From: Martina Novakova
Sent: Friday, 26 June 2026 11:25 AM
To: Delia Galao
Subject: RE: SSD-83789711 - Corrimal Coke Works - Stage 2A - Built Form

I have reviewed the SDRP advice, the RTS material and the Design Excellence provisions under Clause 7.18. While a number of matters have been addressed or partially addressed through the RTS, there are two issues that remain insufficiently resolved:

Figure 11 – Curtilage of the heritage item, as listed on the Wollongong LEP 2009.

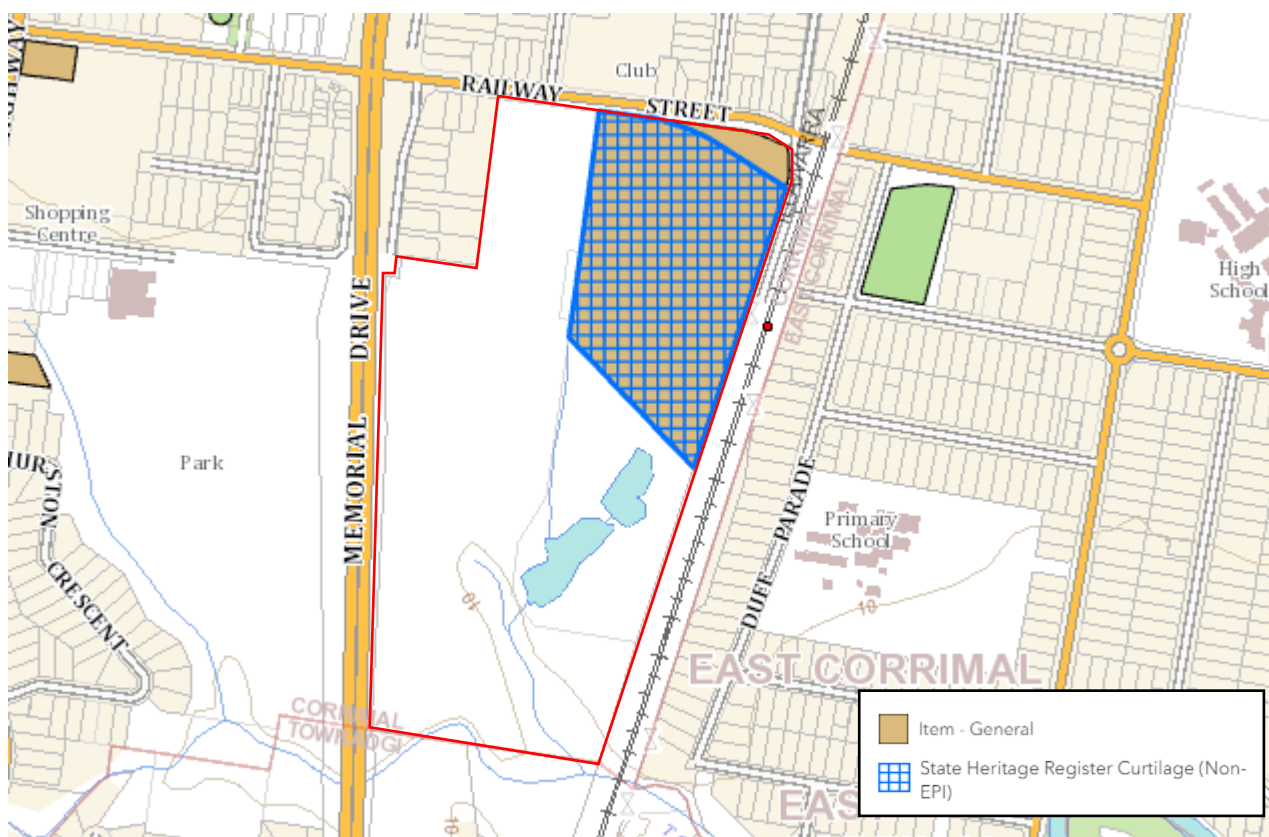
The SDRP identified concerns regarding the relationship between Building 2.2 and the heritage item, including the appropriateness of the building's bulk, scale, setbacks and impact on the heritage setting and curtilage.

Based on the RTS material reviewed, I have not identified a substantive response to these concerns. In particular, there does not appear to be additional justification demonstrating that the increased height and bulk of Building 2.2 achieves an appropriate relationship with the heritage item or maintains an adequate heritage setting and curtilage. As such, it is not clear that this aspect of the SDRP advice has been satisfactorily addressed.
